Your Reference: MP10_0171 MOD 6
Our Reference: NCA/23/2010
Contact: Ashleigh Matta
Telephone: 9806 5600
Fax: 9806 5901

Section 75W Modification request to modify the Project Approval for the mixed use residential, retail and commercial development.

I refer to the public exhibition of the above Major Project seeking approval for the modification of MP10_0171 (MOD 6).

01 PLAN - PODIUM LEVELS 1-3
1:100

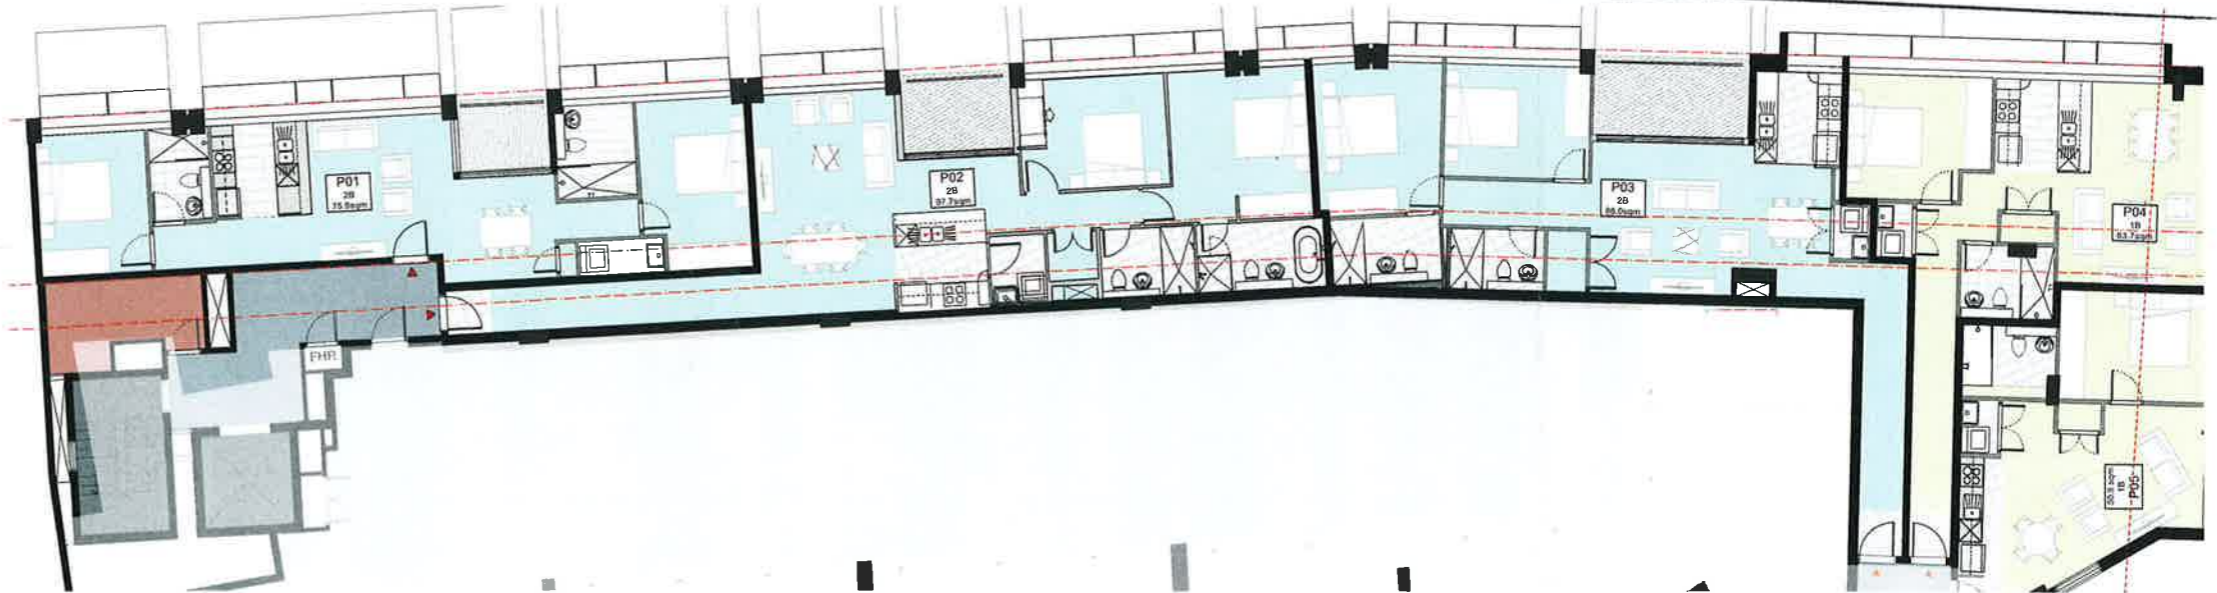
5. ***Provision of additional retail floor space and a 62 space childcare centre.***

Council raises no objection subject to the following being considered:

- A drop off and pick-up area is to be provided for the childcare centre and this is to form part of the assessment of the current modification request.
- Access between the childcare centre and residential units on Level 4 should be considered as part of this current modification request.

As per Council's resolution (b) above Council is of a strong view that a drop off / pick up area for the childcare centre should be located within an appropriate location which minimises traffic and pedestrian conflict around the site entrance to the basement and nearby businesses.

**ELEVATIONS - EAST
TOWER**

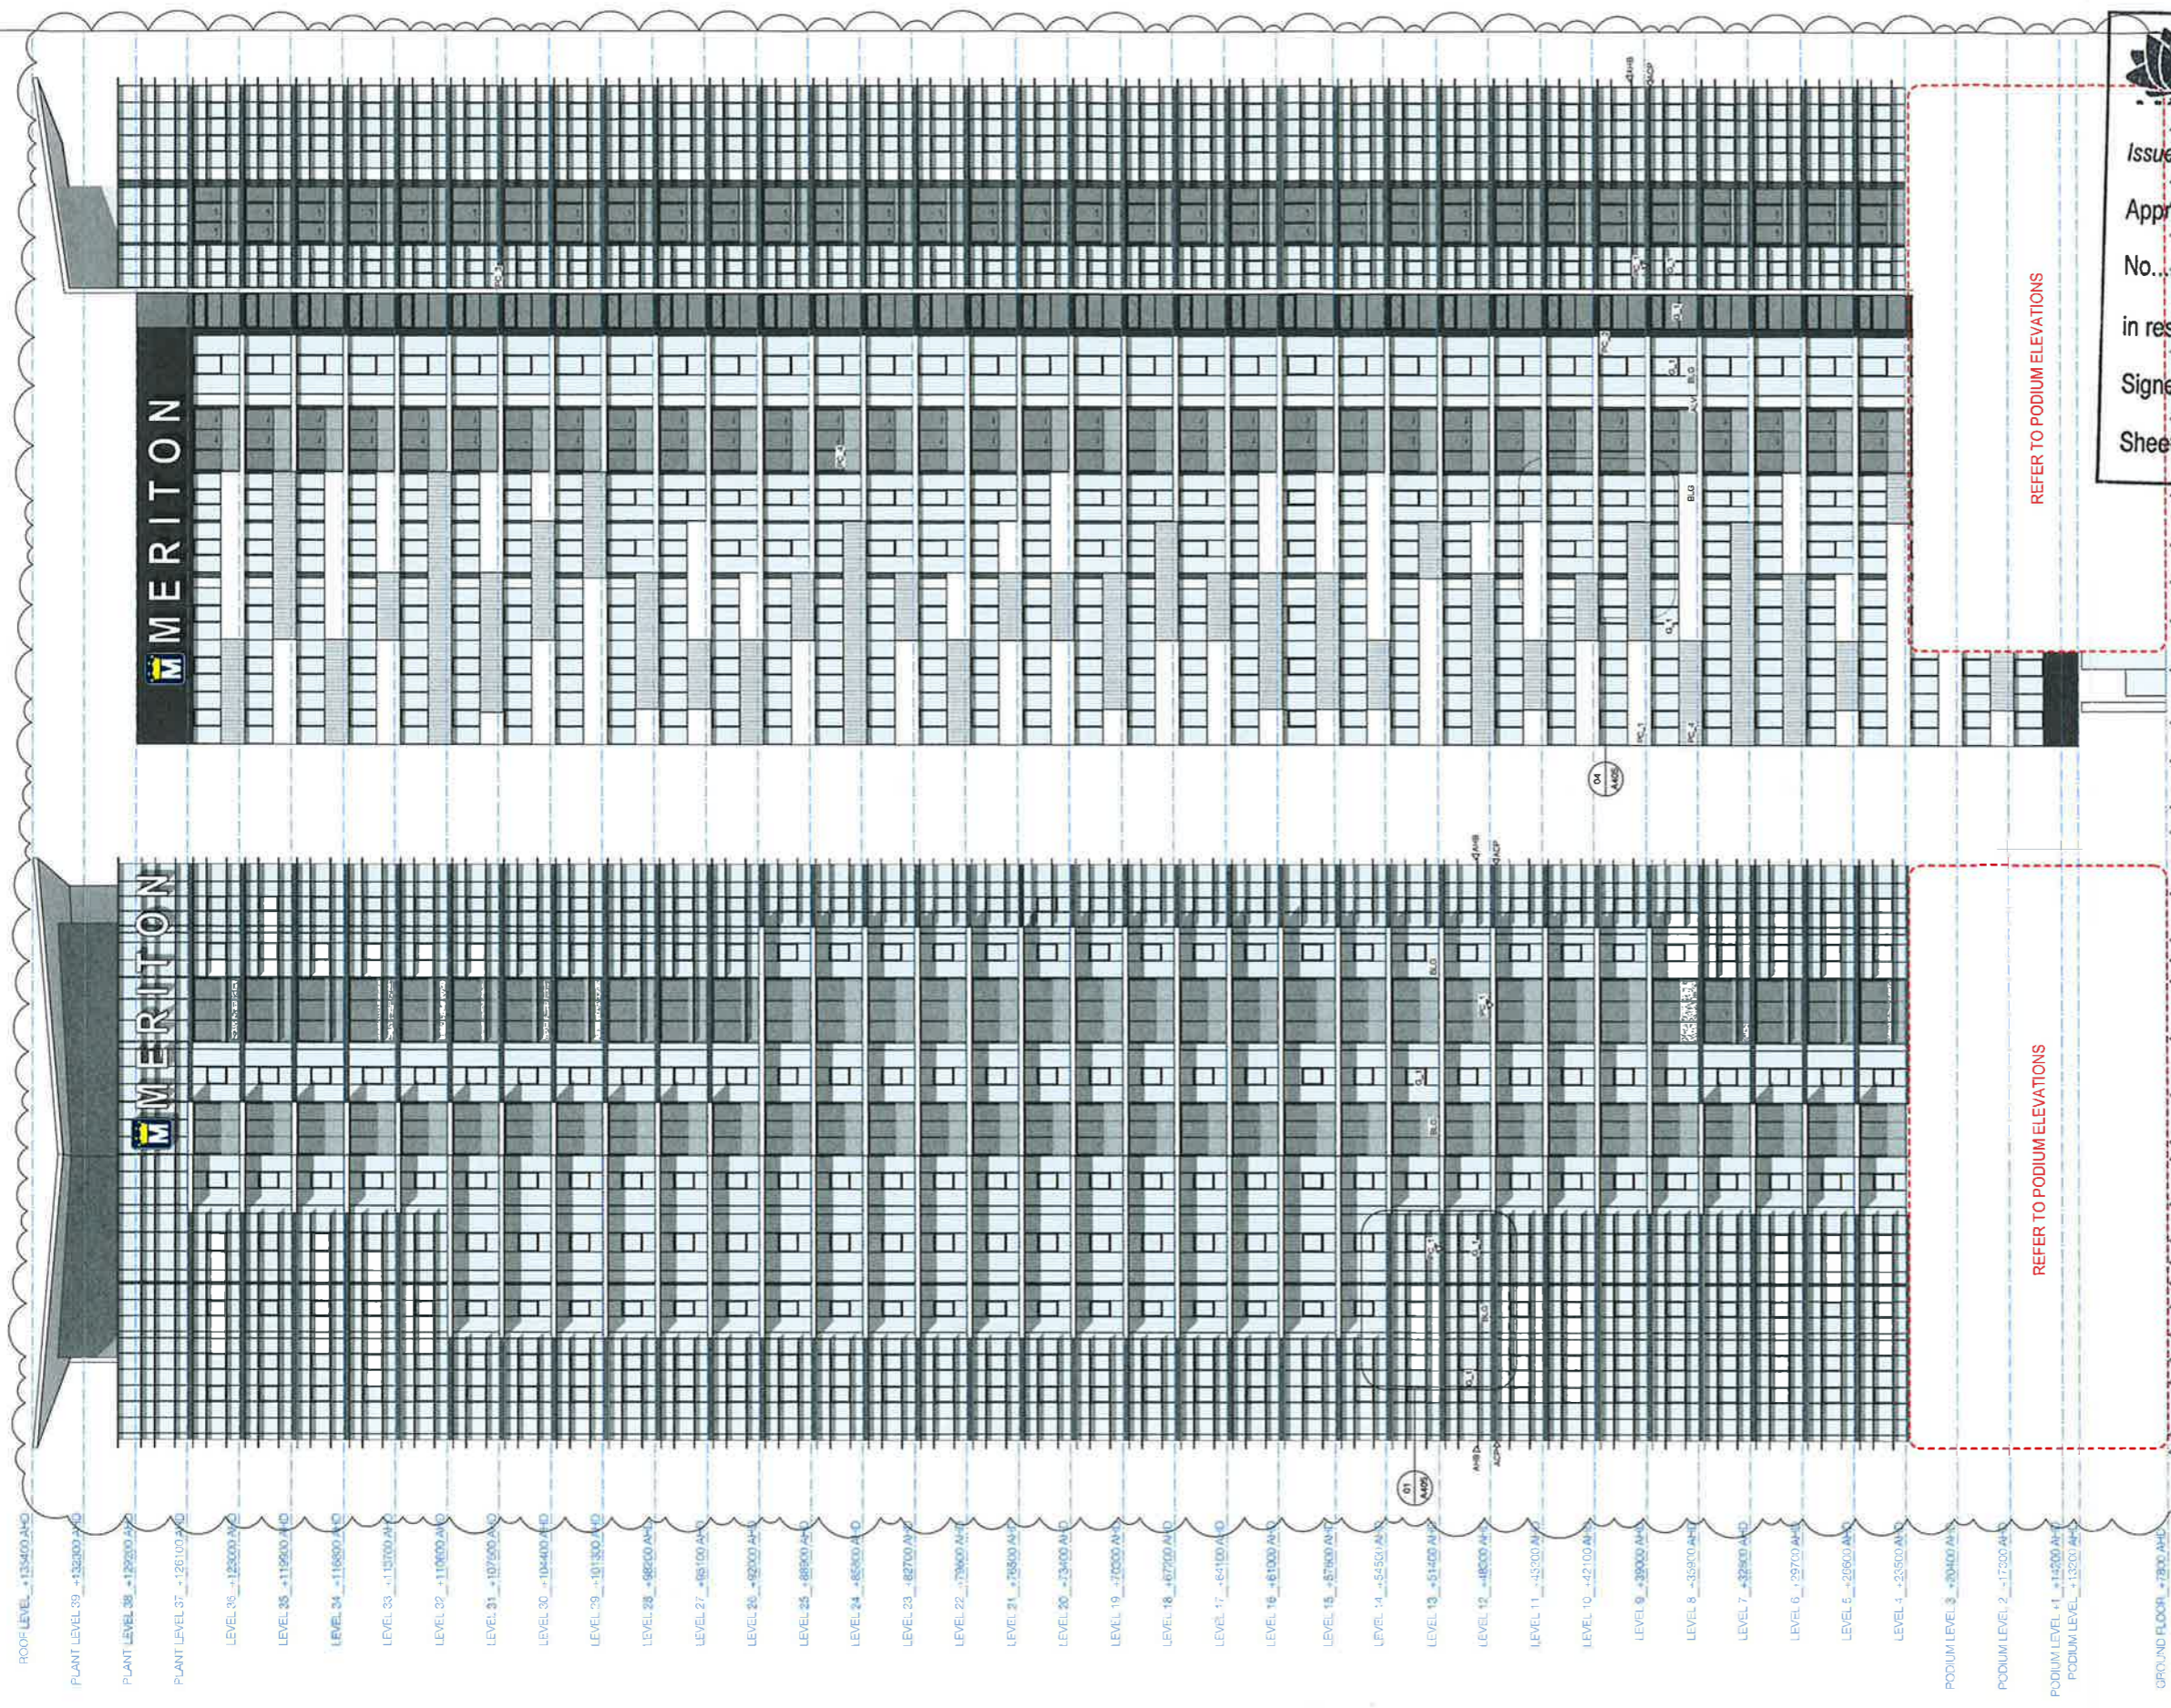
1. ***Increase the height of the serviced apartment building (eastern tower) by six storeys (33 to 39 storeys).***

Council raises no objection to the proposed increase in height subject to the Voluntary Planning Agreement being updated to reflect the additional height.
